From: Richard Temple
Sent: 08 February 2018 10:55
To: Planning.Responses
Subject: FW: BE/128/17/HH 61 Newtown Avenue, Bersted

Sent: Thursday, 25 January 2018, 14:37
Subject: BE/128/17/HH 61 Newtown Avenue, Bersted

1st floor plan

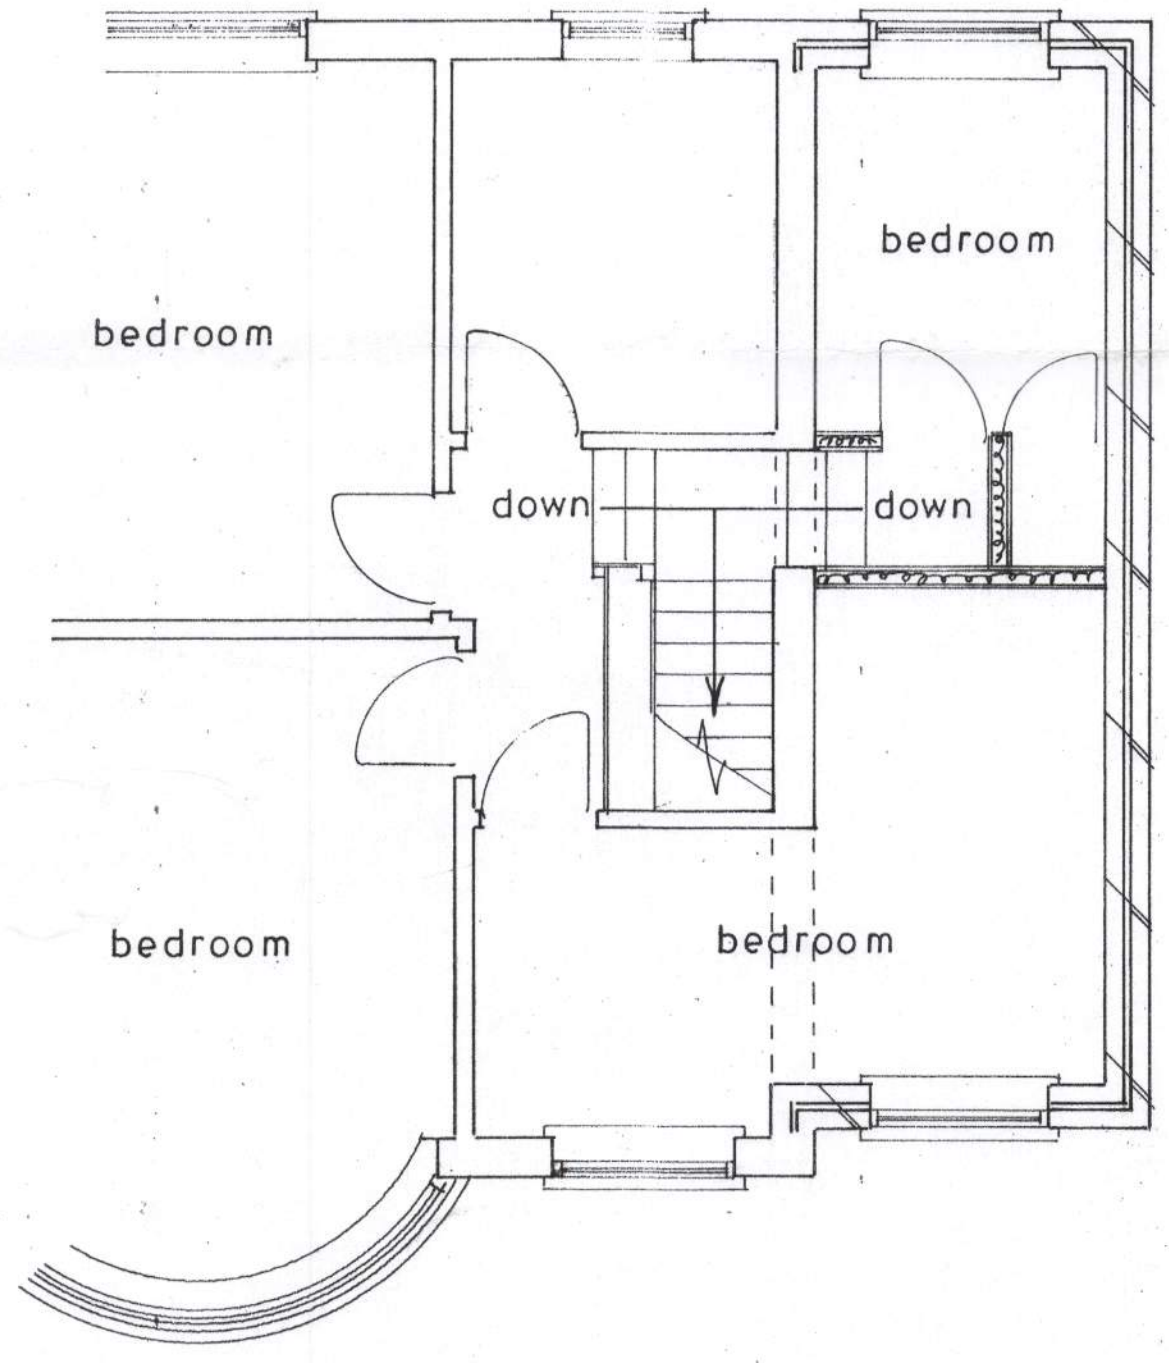
Having spoken to my team leader, would you be able to increase the set off from the common boundary with 59, at first floor level? Ideally to 1m off.

Taking note of the dismissed at appeal at 13 Newtown Avenue in 2015 (BE/120/68/14/HH) we have to have more regard to sections (iv) & (v) of DEV19 below:-

Note that no set off at ground floor is required, so the extension could be built right up to the boundary at that level.

I confirm my client's instruction to withdraw the application as the 1st floor amendment is just not practical.
